**From:** April Collinson <readparishcouncilclerk@gmail.com>  
**Sent:** 05 January 2023 16:56  
**To:** Planning  
**Subject:** Re: Consultation on planning application 3/2022/1129 Bridge Hey Wood Caravan Park, Dunkirk Farm, Read BB12 7RR

The application is for retrospective change of use with minor engineering works and associated landscaping works for the reuse of the former railway embankment and track bed to form an informal recreational amenity area in association with the adjacent holiday park.

Site Plan

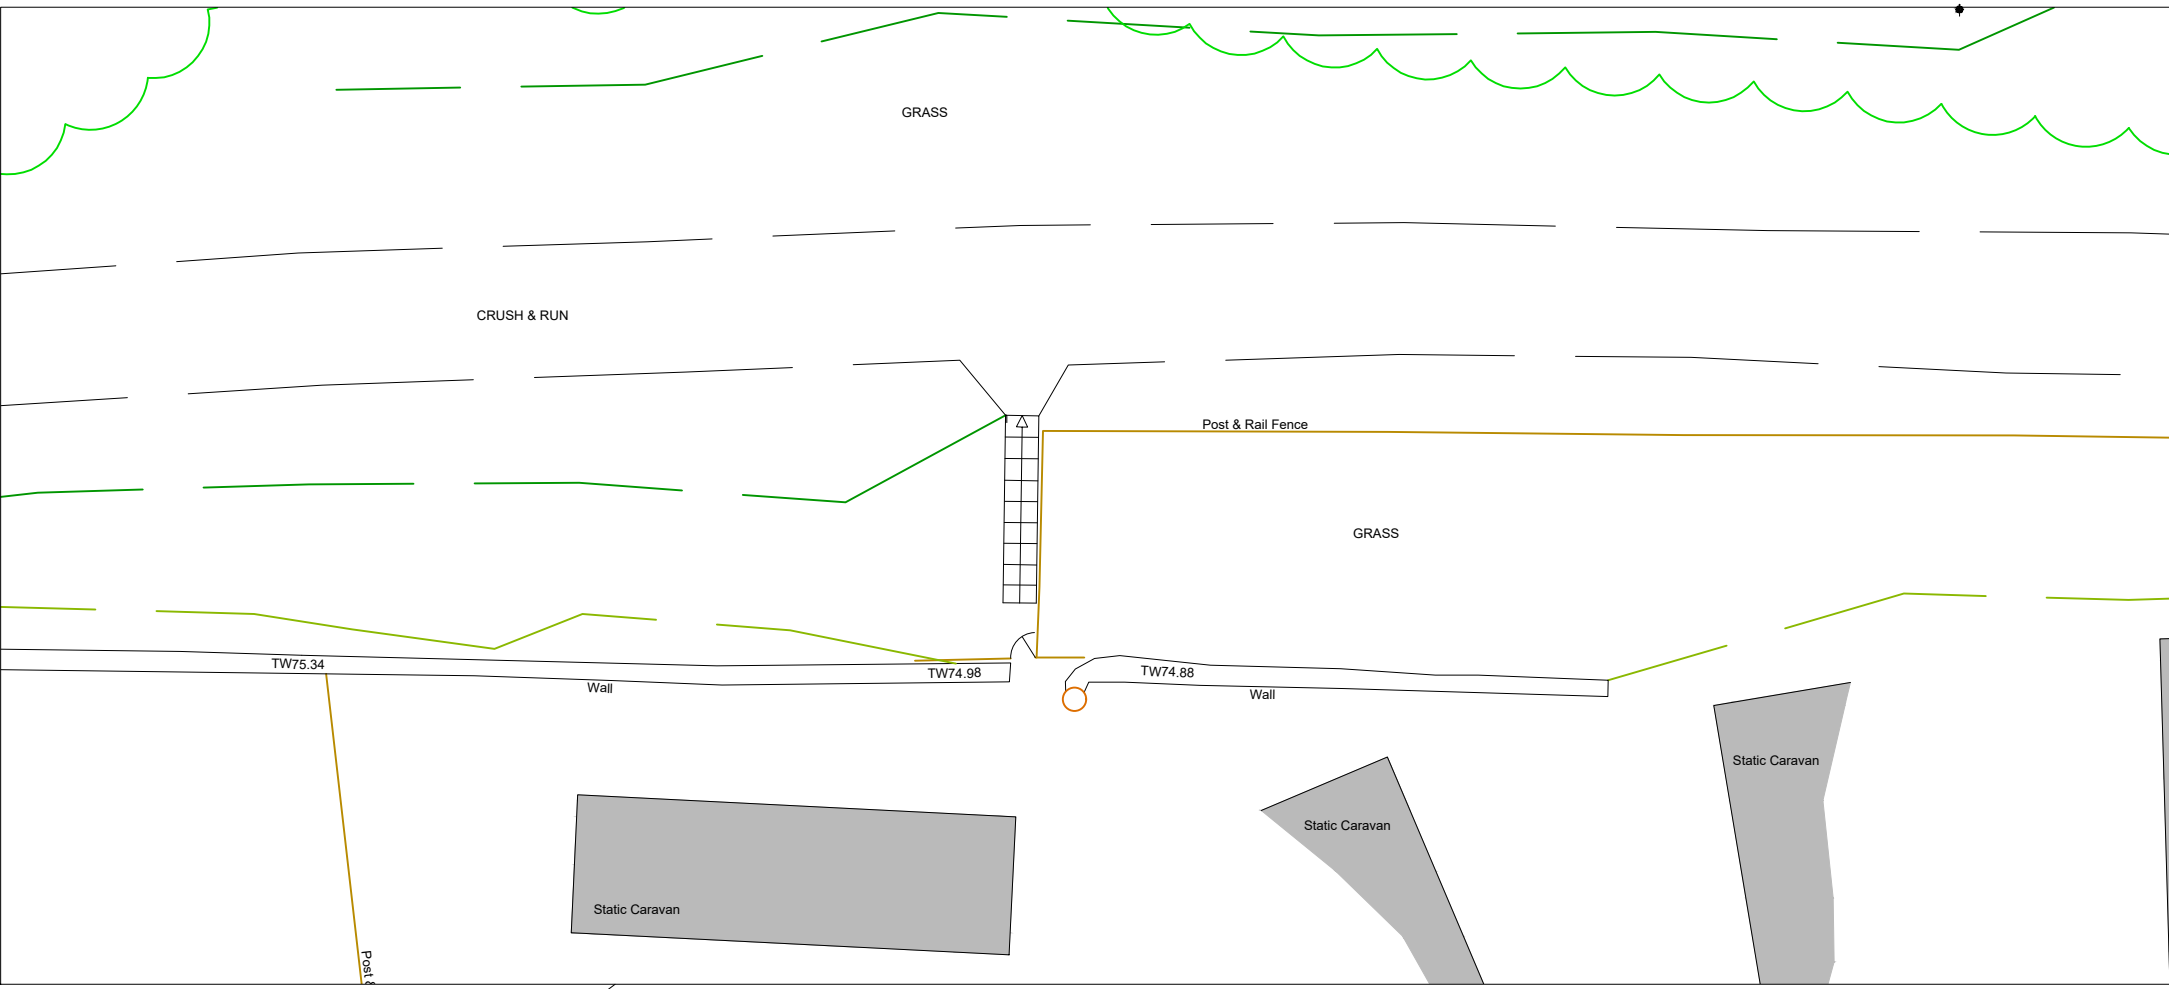
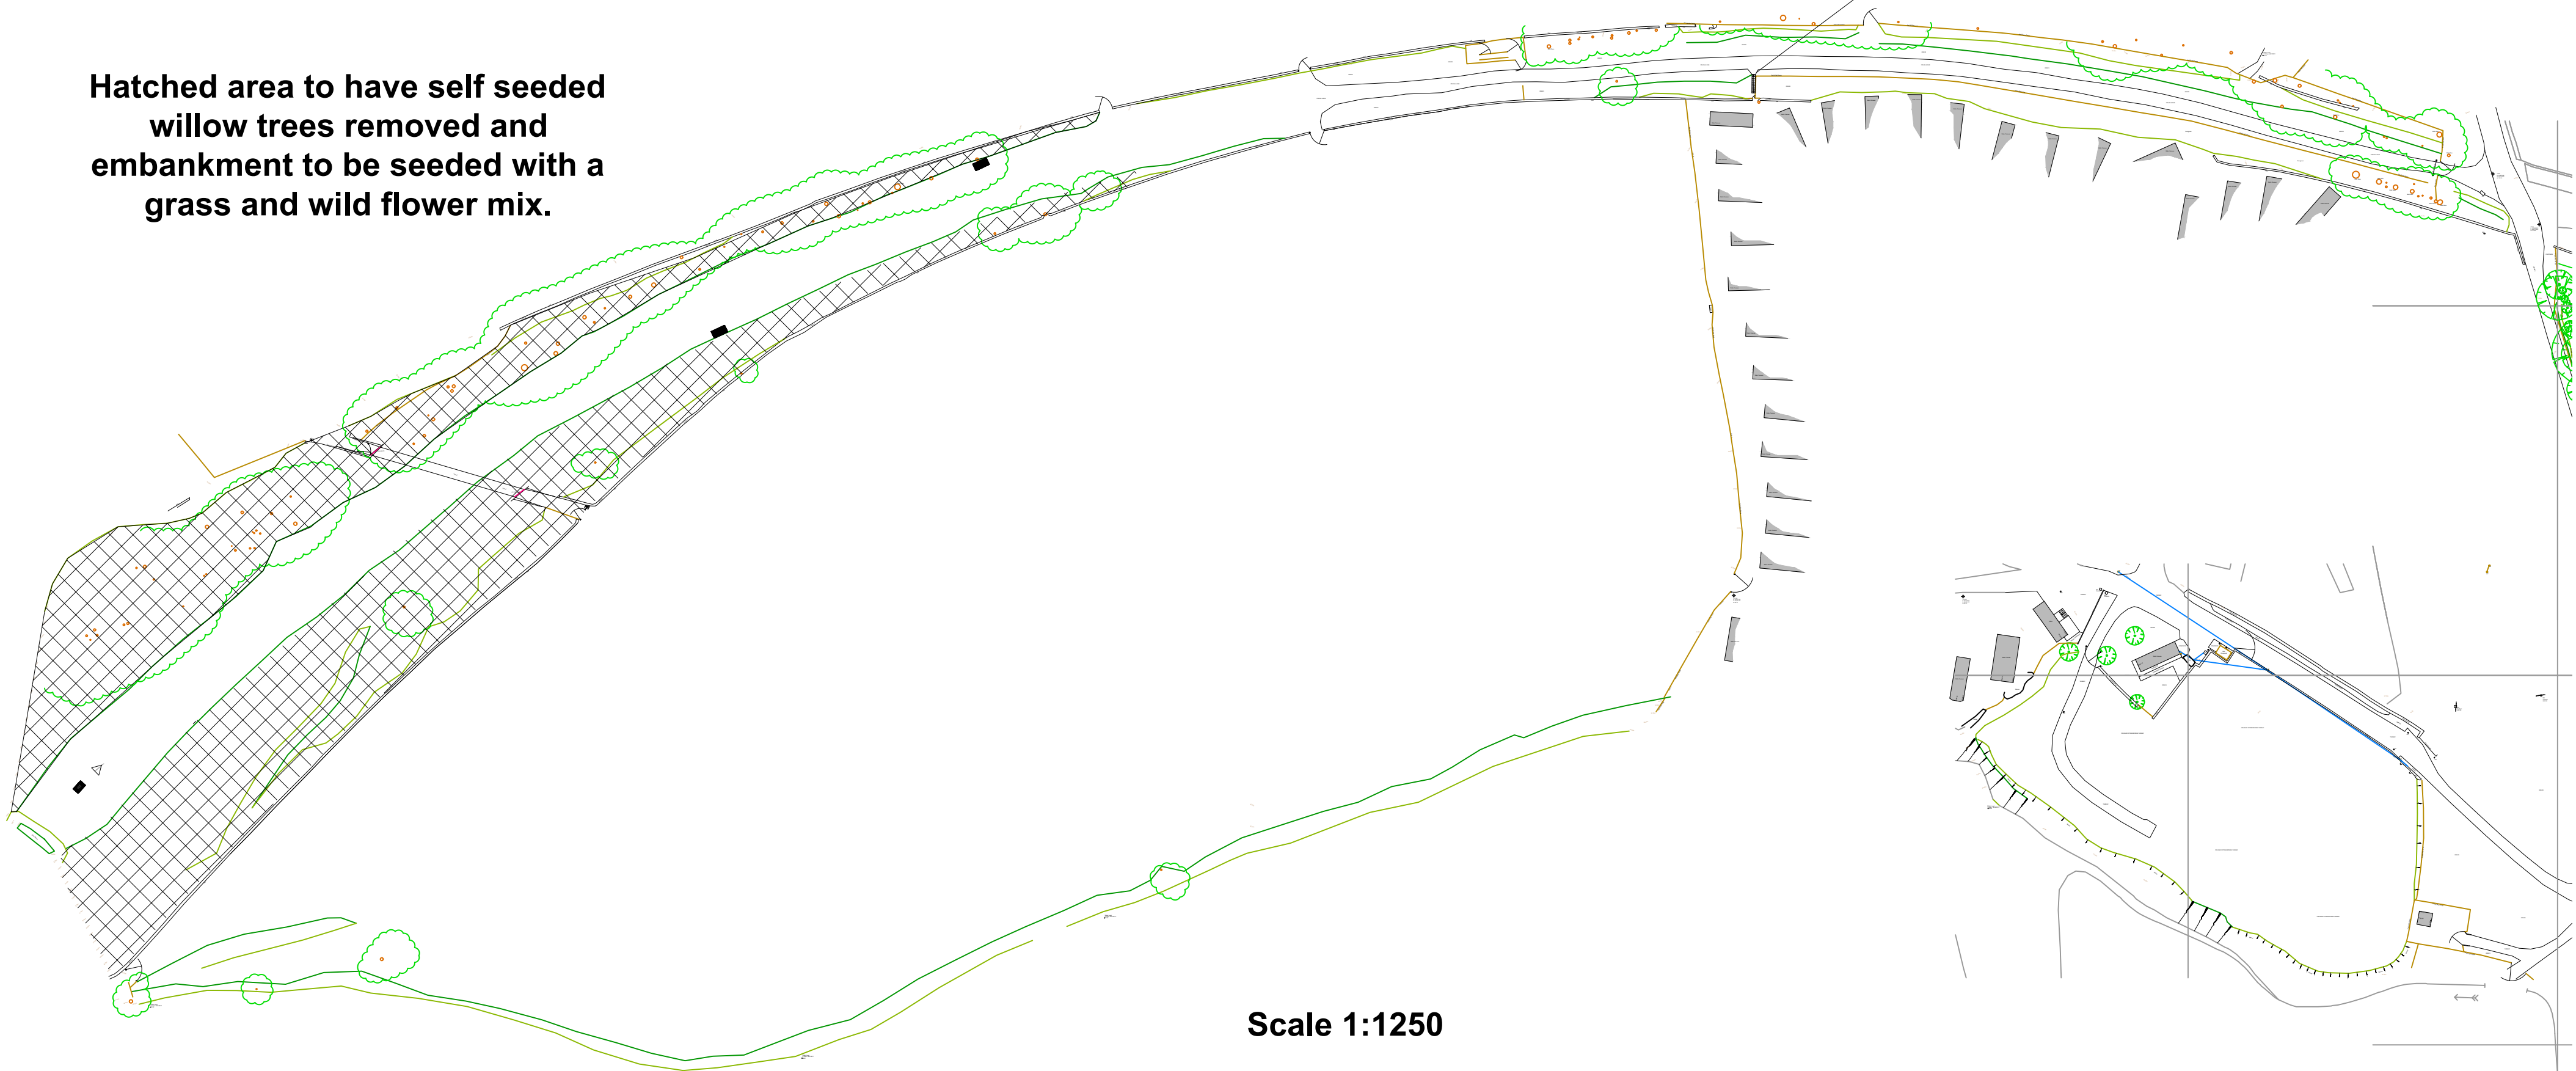
1. In the planning application it is stated that no trees were on the site however it appears multiple mature (70-80yrs+) trees have been removed from the site.

5. The planning documents note a footpath which travels under the Viaduct, this is not a footpath owned by the Caravan Park and actually belongs to Railway Paths
